Portland Water District

September 22, 2016

Re: 314 Presumpscot Street, Portland
Ability to Serve with PWD Water

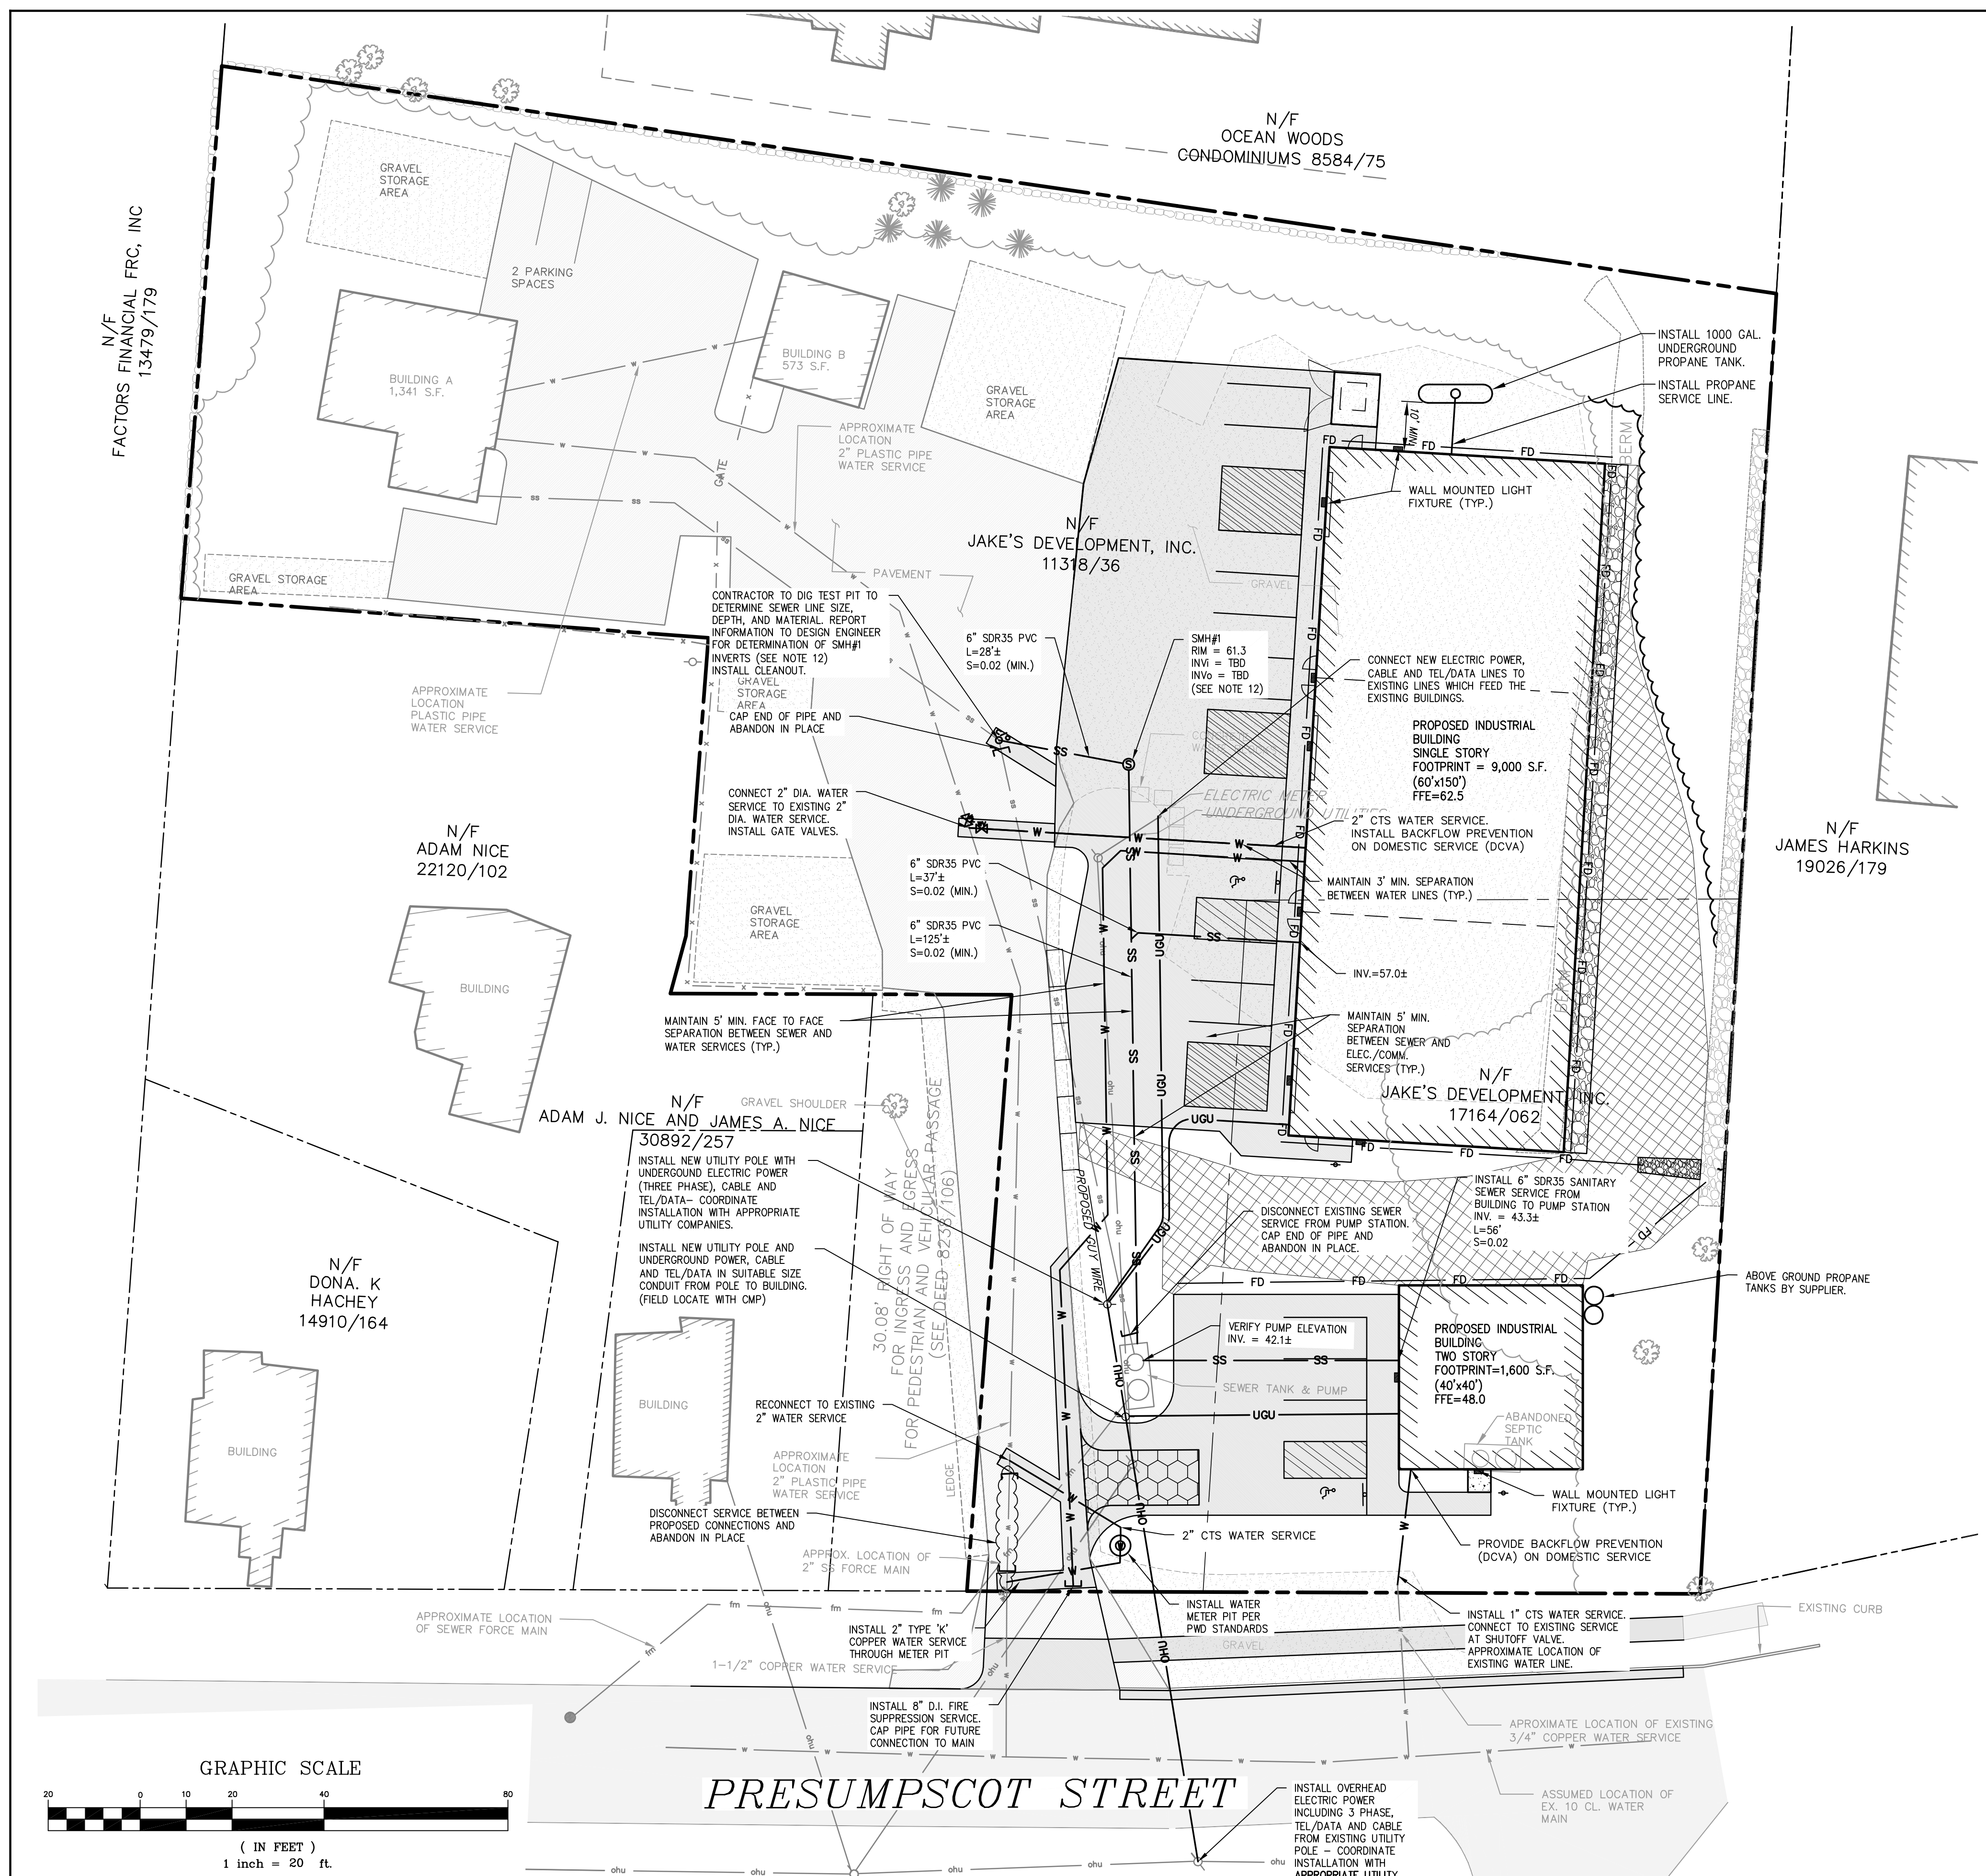
- A new 1-inch domestic service to serve Building B, 2-inch domestic service to serve Building A, and a new 4-inch fire service to serve the property may be installed from the water main in Presumpscot Street per utility configuration plans dated 9/21/16. The service should enter through the properties frontage on Presumpscot Street at least 10-feet from any side property lines.

- The existing building is currently served with a ¾-inch domestic water service; the size of this service is undersized for the proposed use. This service must be terminated by shutting the corporation valve and cutting the pipe from the water main.

- If the length of this service line will exceed 300-feet, a meter pit will be required. The meter pit should be located on private property within 10-20 feet of the property line at Eastman Road.
